Recommendation Report for Planning Permission**REF NO:** K/1/12/**LOCATION:** 29 Golden Avenue
East Preston**PROPOSAL:** Side extension to provide garage and store (re-submission following K/25/11)**SITE AND SURROUNDINGS**

PROPOSED ROOF PLAN

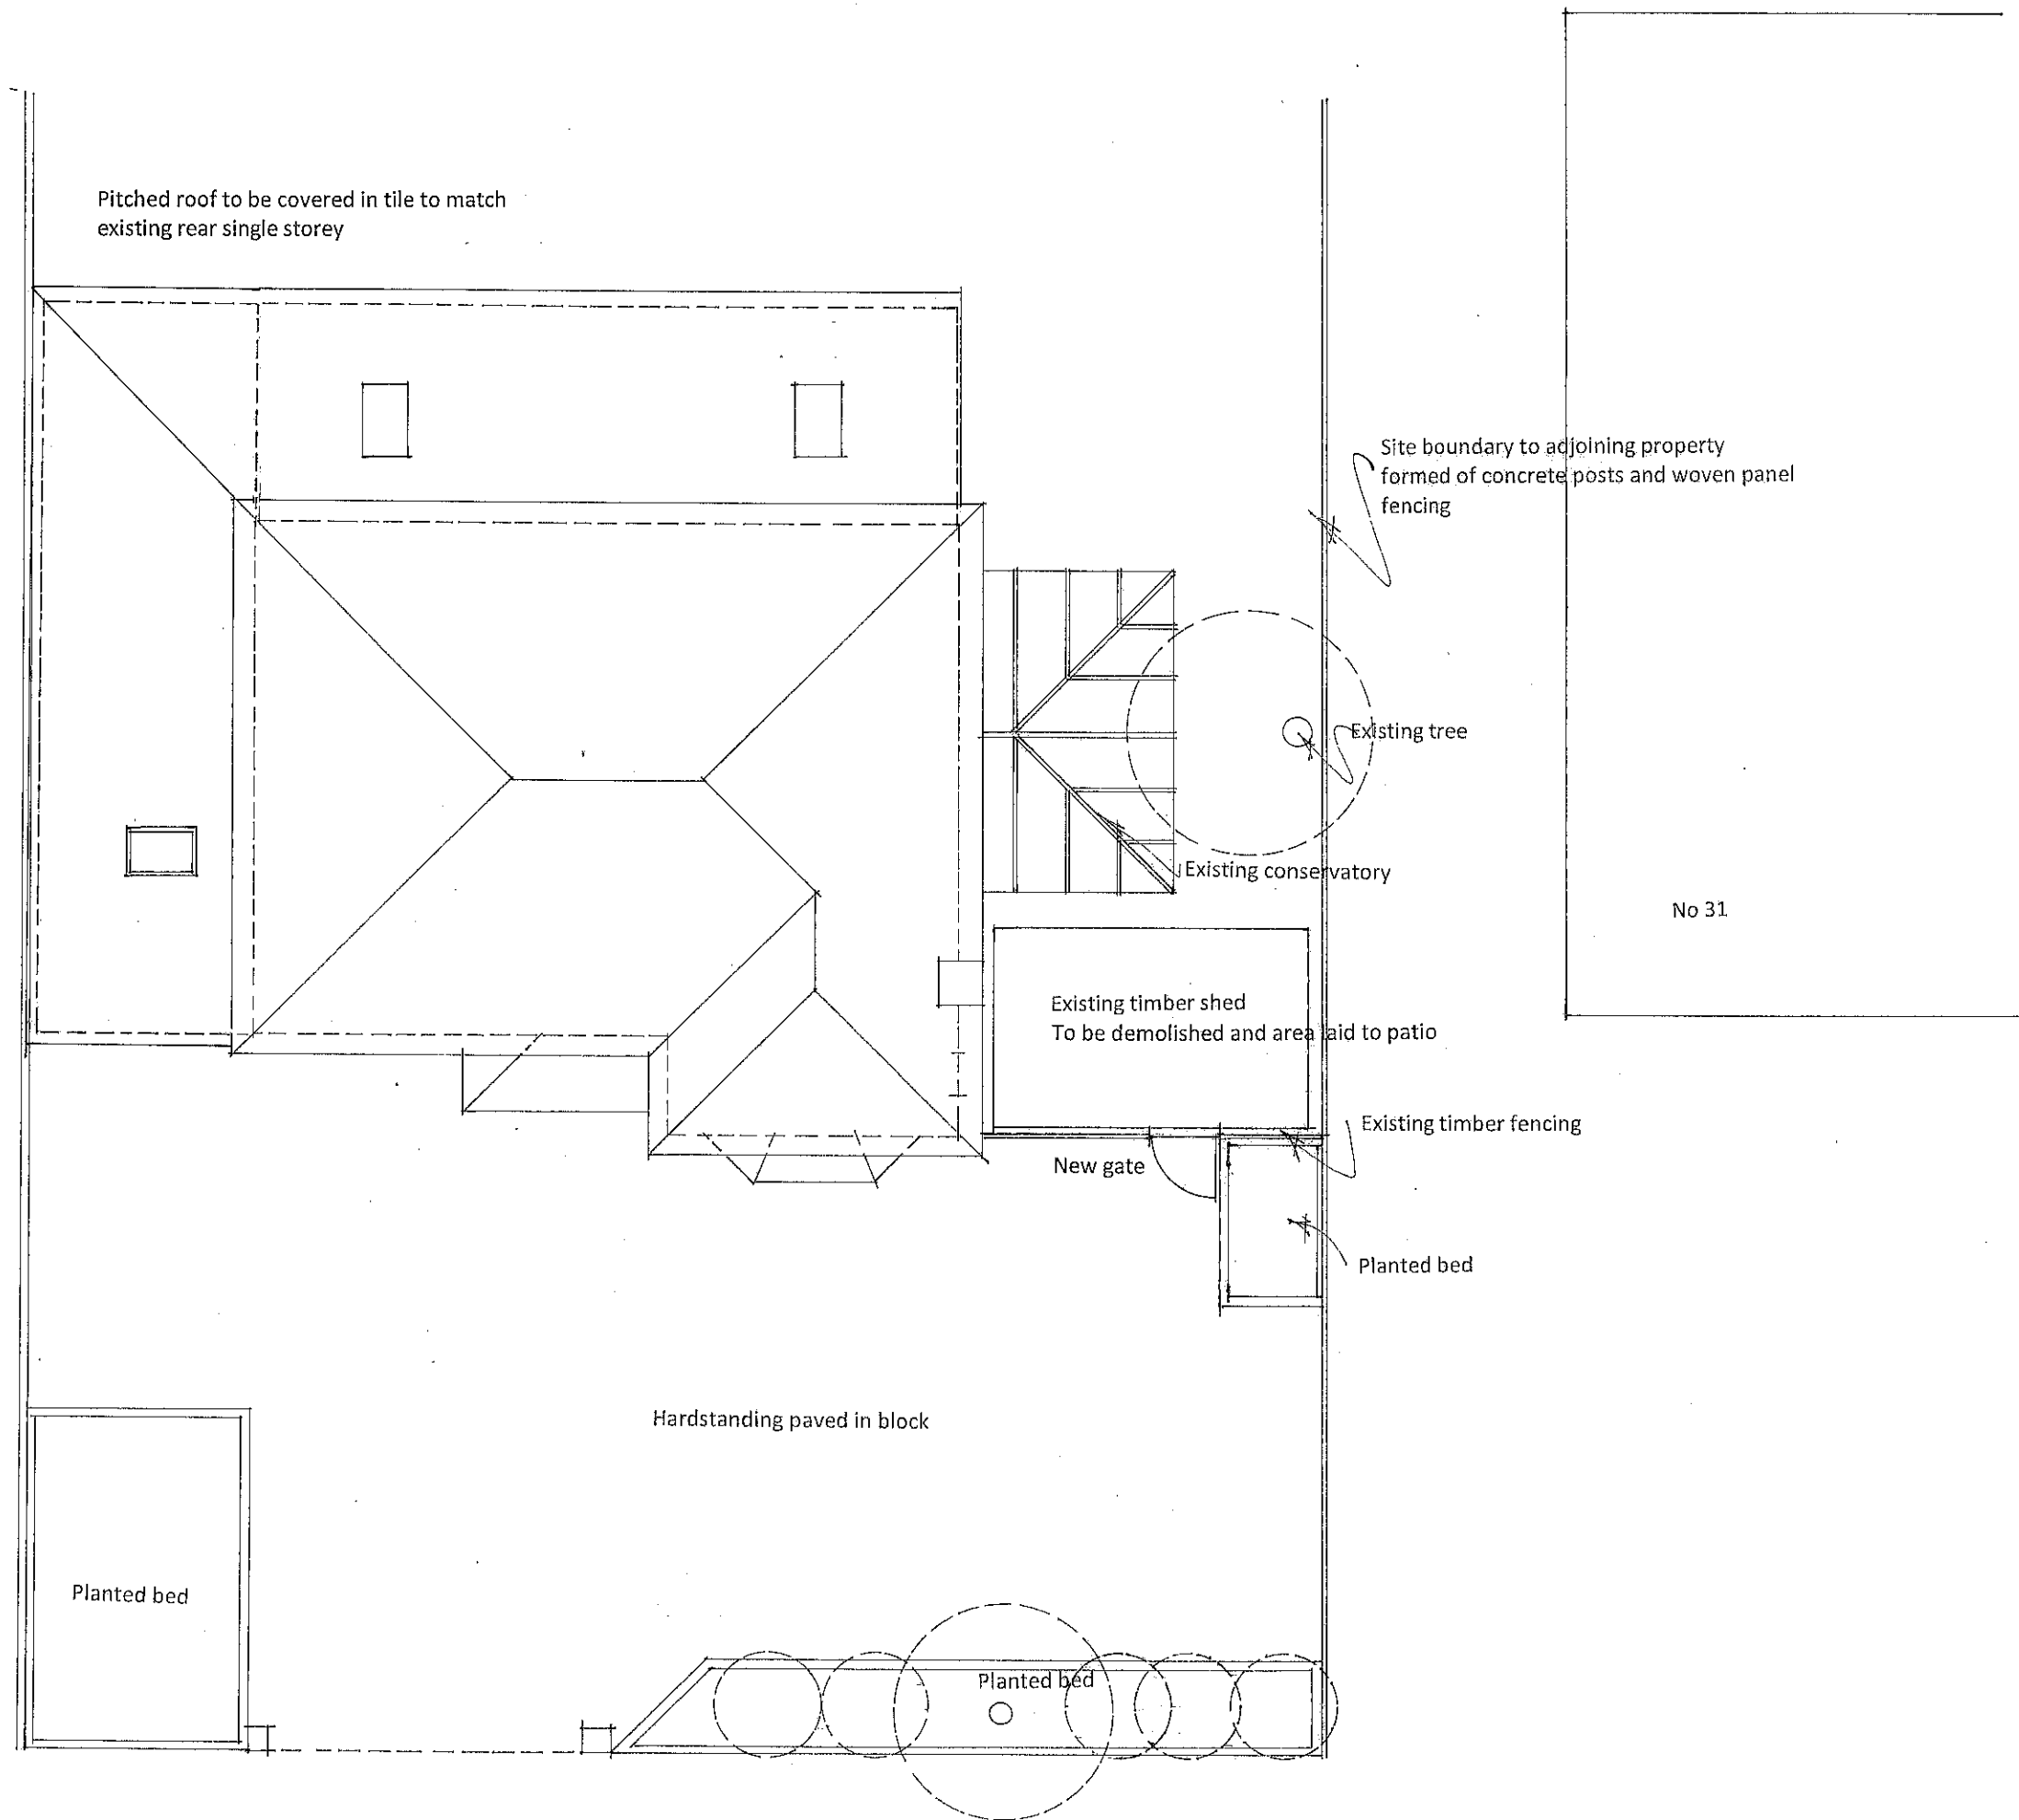
It is acknowledged that the proposed extension will be positioned alongside the northern site boundary. However, at single-storey height, with the roof pitching away from the boundary, it is not considered that it would appear overbearing, nor would it bring about undue levels of overshadowing towards nearby windows, particularly given the impact of the existing two-storey building some 3 metres from the boundary. The only openings in the structure would be a roof light which would be set at a high level above the floor and unable to offer intrusive views of the neighbouring property. There will also be doors to the rear of the extension from which views towards neighbouring properties will be interrupted by existing site boundary treatment.

PROPOSED ELEVATIONS SHEET 1

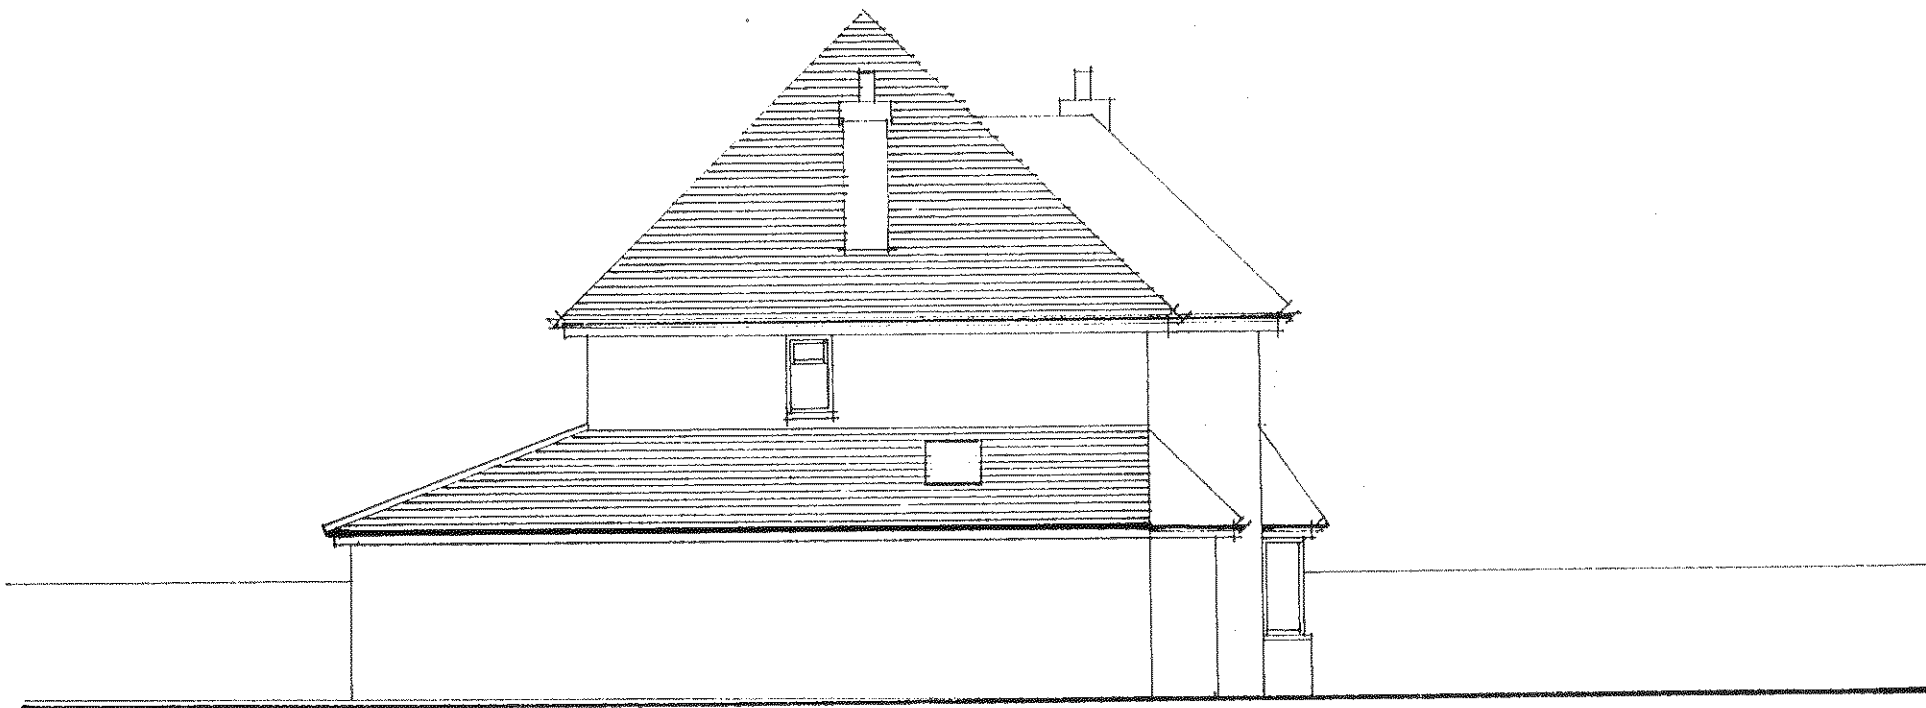
The proposal will increase the width of the dwelling frontage but, unlike the previous scheme, would not project to the front of the dwelling, therefore maintaining the spatial relationship

between the building and the road and not disrupting the open and spacious nature of plot frontages. The overall visual impact will be minimal due to the modest proportions of the extension. As mentioned above, it is possible to build at single-storey height up to the boundary line under householder permitted development rights. It is not considered that a concentration of such features would engender a terraced appearance to dwellings as they would be single-storey only. It is therefore considered that there will be no detrimental impact upon the character and appearance of the surrounding area.

The proposed extension is of a modest height and area and it is considered that it would clearly appear visually subservient towards the existing dwelling. Although the footprint of the original dwelling has already expanded as a result of existing extensions, and will be further increased as a result of the proposal, it is considered that size of the plot is ample to accommodate such growth without an unacceptable loss of amenity space. The pitched roof design of the extension will compliment that of the existing dwelling roof and will also visually assimilate with the existing rear extension, ensuring an integrated and cohesive appearance to the various extensions made to the original building.
